KIRKLEES METROPOLITAN COUNCIL INVESTMENT & REGENERATION SERVICE

DELEGATED DECISION TO DETERMINE PLANNING APPLICATIONS

Reference No:	2026/62/91042/E
Site Address:	8, Hartley Grove, Dewsbury, WF13 2BL
Description:	Erection of 3 storey side extension with rear dormers and front porch
Recommending Officer:	Jennifer Booth

DECISION - REFUSED

PROPOSED GROUND FLOOR PLAN
1:100@A1

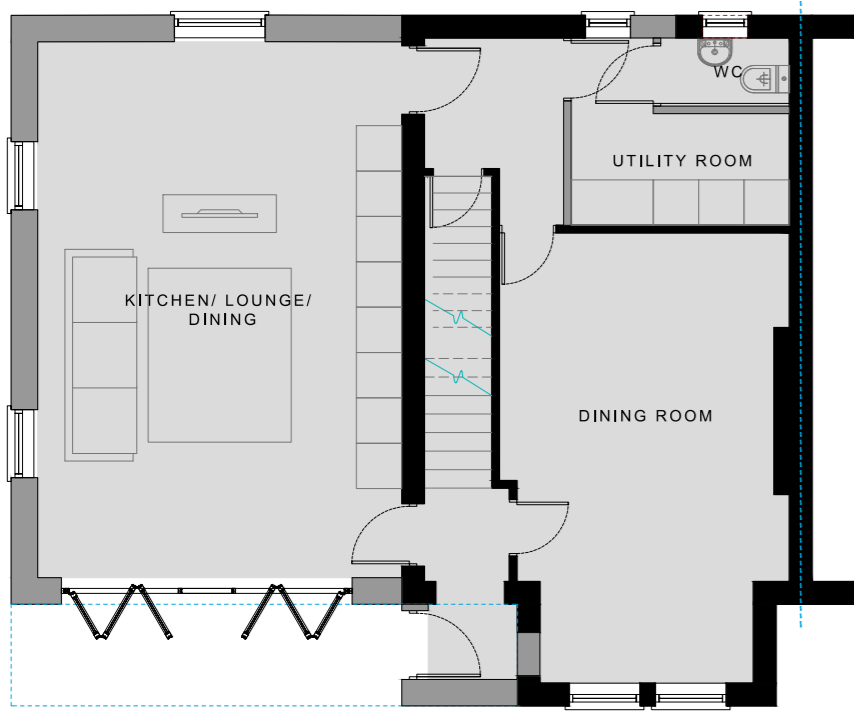
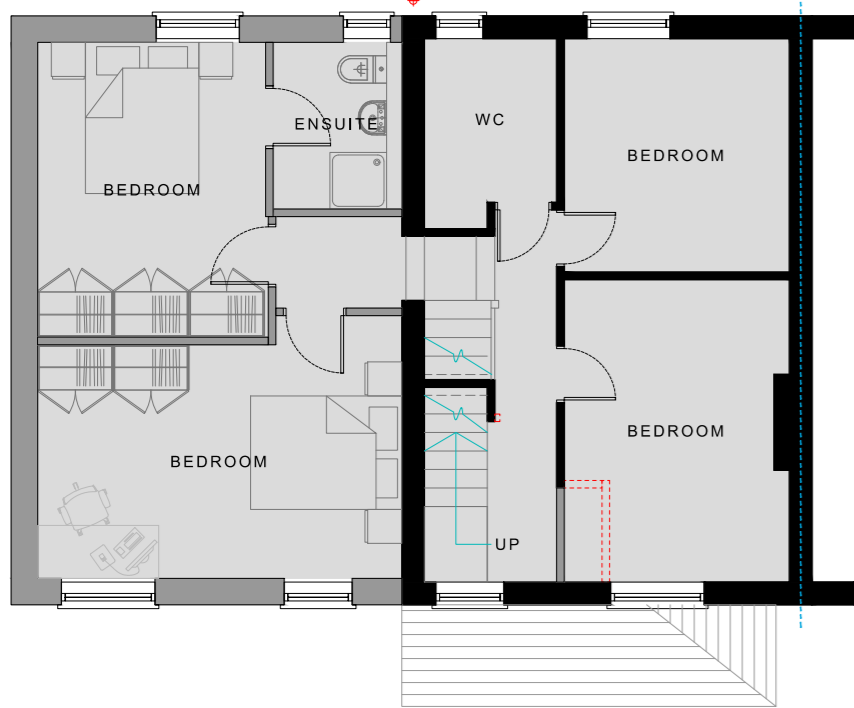
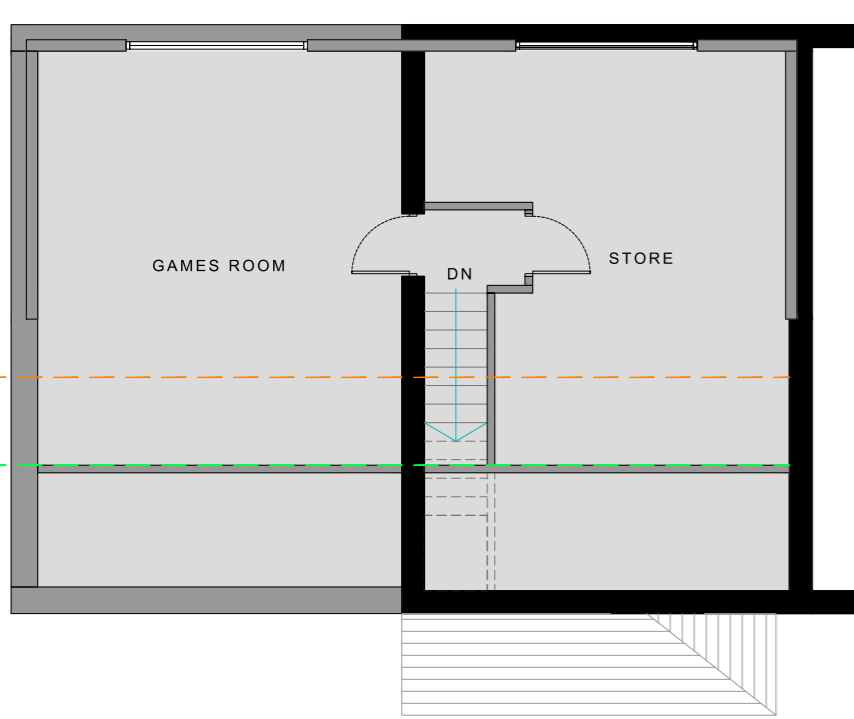
In addition, the submitted plans indicate the inclusion of a window within the side elevation of the extension. Although described as serving a secondary function, this window would nonetheless provide outlook from a habitable room. Its size and positioning would allow direct views towards the neighbouring property, including both its private amenity space and rear-facing windows. As such, it would give rise to material concerns regarding loss of privacy and overlooking, further compounding the overall impact of the proposal.

In particular, the development would create a more direct and pronounced relationship with No. 46 to the rear. The proposed layout introduces habitable room windows facing towards the neighbour's rear elevation, including a kitchen/lounge/diner at ground floor level and a bedroom window at first floor level. This arrangement would result in increased opportunities for direct overlooking into the neighbouring property's private amenity space and rear-facing windows.

The proposed development would introduce a side elevation window serving a habitable room, which, despite being described as secondary, would afford direct views towards the neighbouring property at No. 4 Hartley Grove. Given the relative site levels, with the host property positioned at a higher elevation, this relationship would result in an unacceptable degree of overlooking and loss of privacy to the neighbouring property's rear elevation and private amenity space. To permit the proposals would be contrary to Policy LP24 of the Kirklees Local Plan, KDP3 & KDP6 of the House Extensions & Alterations SPD and Chapter 12 of the National Planning Policy Framework.

By reason of its increased width, elevated position and close proximity (approximately 10 metres), the proposed extension would create a more direct and intensified relationship with No. 46 Hartley Street. The inclusion of habitable room windows at both ground and first floor levels facing towards this neighbouring property would result in harmful overlooking. Furthermore, the scale and massing of the extension would give rise to an overbearing and dominating impact, to the detriment of the residential amenity of the occupiers of No. 46. To permit the proposals would be contrary to Policy LP24 of the Kirklees Local Plan, KDP3 & KDP6 of the House Extensions & Alterations SPD and Chapter 12 of the National Planning Policy Framework.

DRAWING TITLE:
GROUPED PLANS

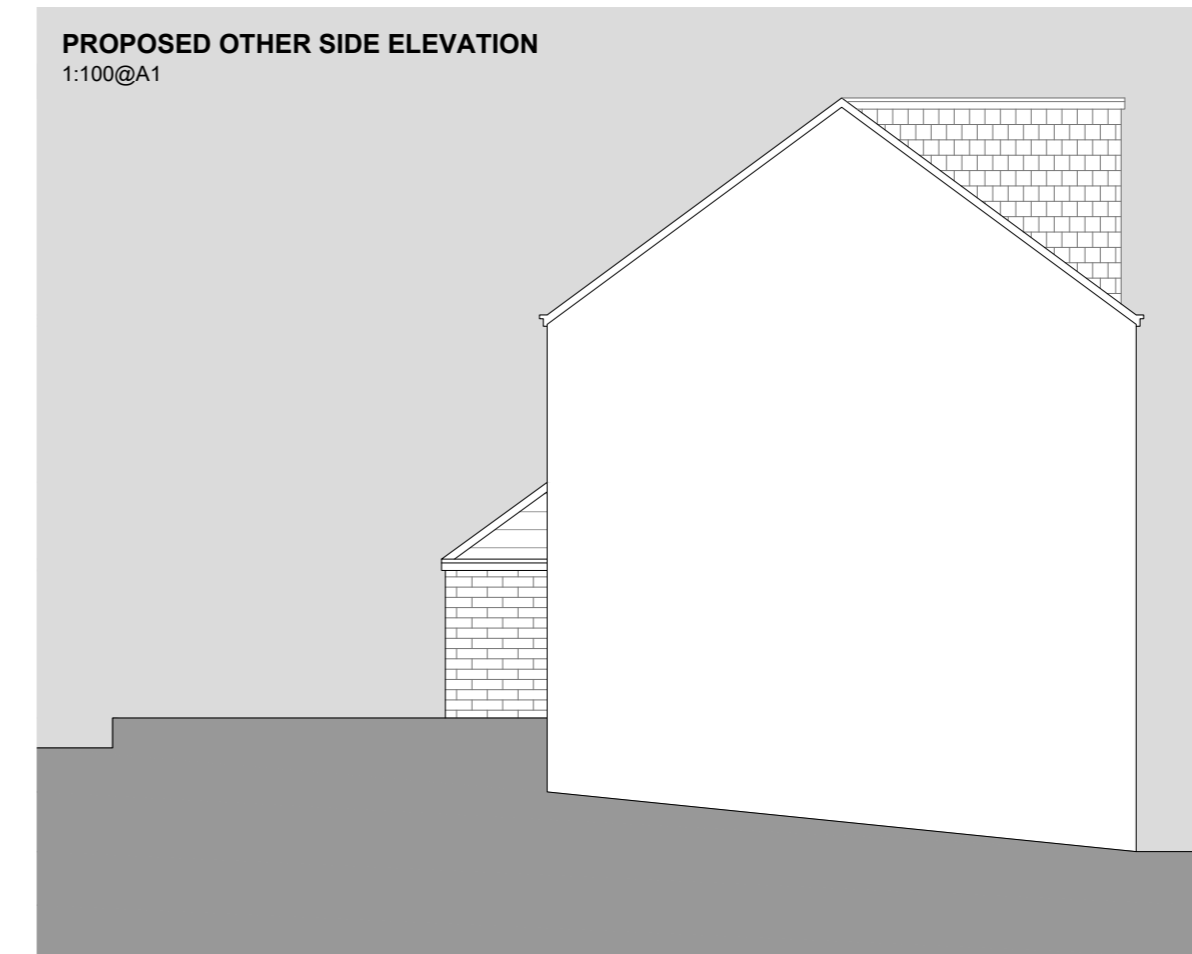
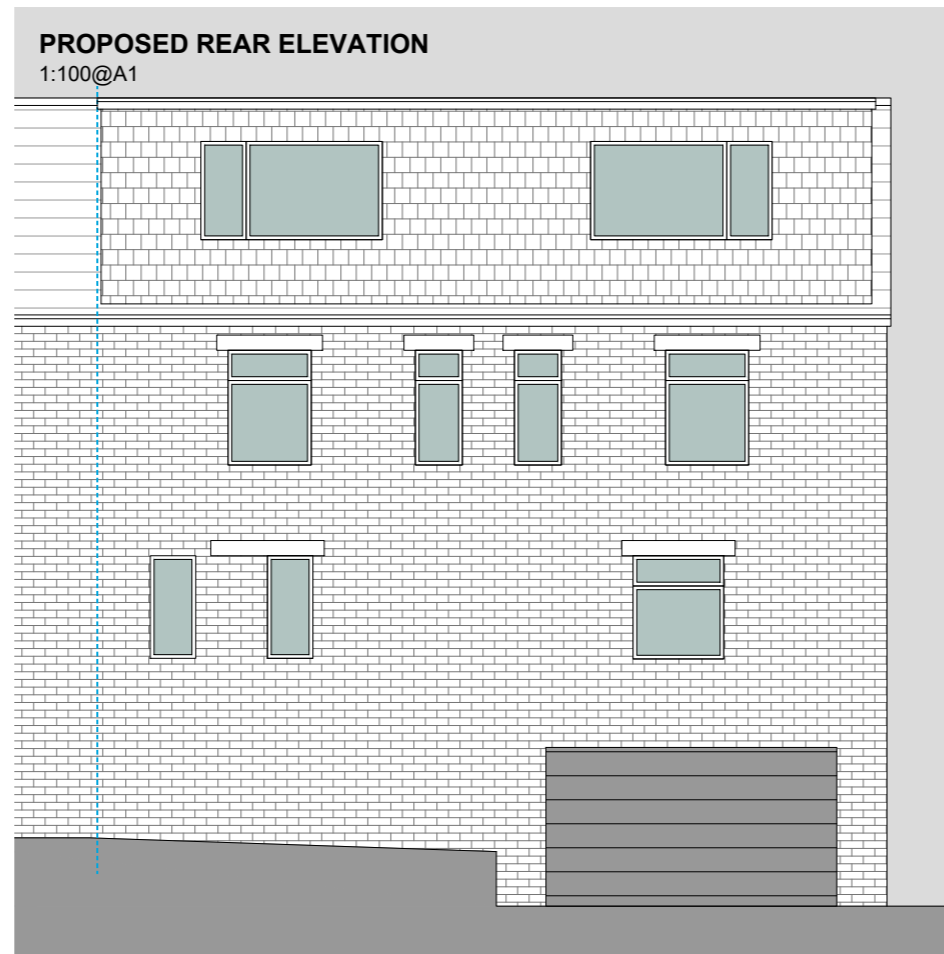
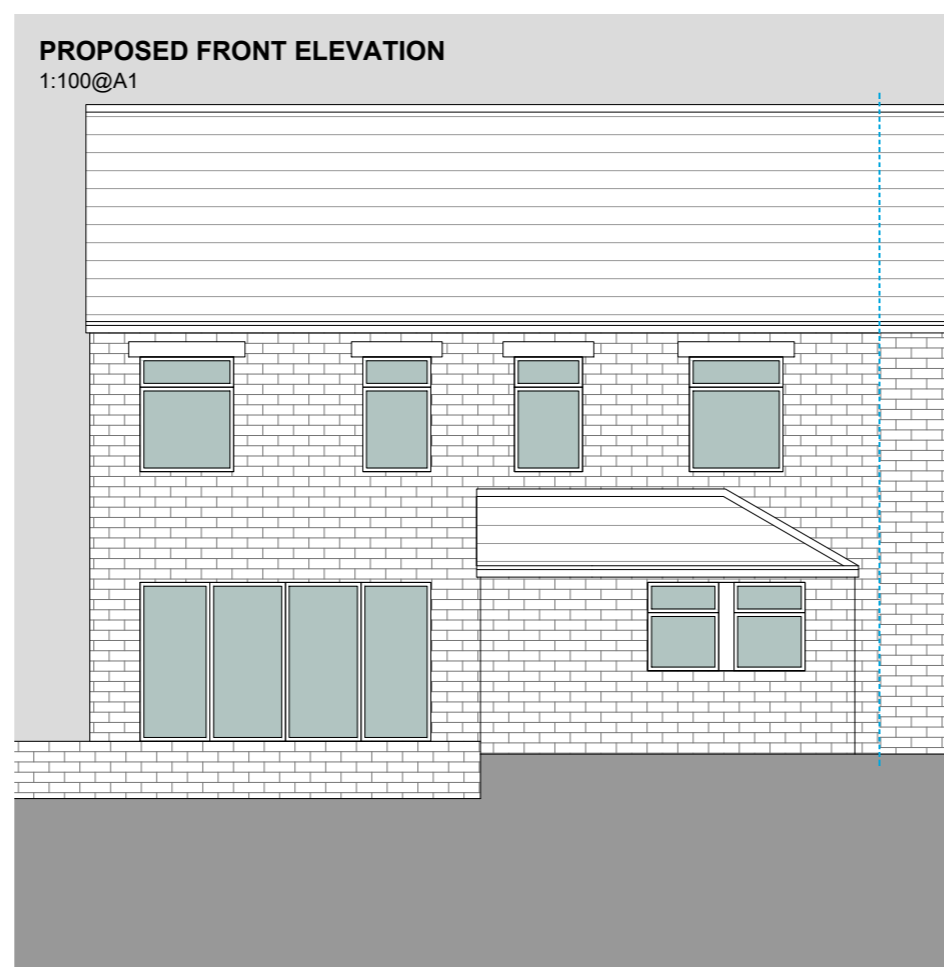
The proposed two-storey side extension, by virtue of its siting and scale, would have a notable impact on the visual amenity of the host dwelling. Whilst the application indicates that materials would match those of the existing property, which would assist in achieving a degree of visual cohesion, the extension would not be set down or set back from the principal elevation and would appear as a dominant addition. Furthermore, the overall bulk and footprint of the extension would exceed that of the original dwelling, resulting in a form of development that appears disproportionate and would not be subservient to the original building, to the detriment of the character of the host property. However, it is acknowledged that the dwelling is not located within a traditional linear streetscene, and a gap would still be retained to the side boundary, which would provide some visual relief and mitigate the perception of a terracing effect. On balance, despite these mitigating factors, the scale and positioning of the extension would result in a form of development that appears overly dominant and fails to respect the proportions of the original dwelling.

The proposed rear dormer extension, by reason of its substantial scale and bulk, would appear as an overly prominent and incongruous addition to the host dwelling. Its size would dominate the roof slope, resulting in a form of development that is not sympathetic to the proportions or character of the existing building. While it is noted that the dormer would be finished in vertically hung tiles, which could assist in integrating the materials palette with the host property, this would not sufficiently mitigate the visual impact arising from its excessive scale. Consequently, the dormer would represent a visually intrusive feature that detracts from the overall appearance of the dwelling.

The proposed two-storey side extension, by reason of its width, scale and massing, would not appear subservient to the host dwelling. Instead, it would visually compete with the original building and disrupt its proportions, resulting in an incongruous and overly dominant addition that is harmful to the character and appearance of the host property and the wider street area. To permit the proposals would be contrary to Policy LP24 of the Kirklees Local Plan, KDP1 & KDP2 of the House Extensions & Alterations SPD and Chapter 12 of the National Planning Policy Framework.

The proposed rear dormer extension, due to its excessive size, bulk and extent across the roof slope, would appear overly prominent and unsympathetic to the form of the existing roof. As such, it would represent a visually intrusive and incongruous feature that detracts from the character and appearance of the host dwelling. To permit the proposals would be contrary to Policy LP24 of the Kirklees Local Plan, KDP1 & KDP2 of the House Extensions & Alterations SPD and Chapter 12 of the National Planning Policy Framework.
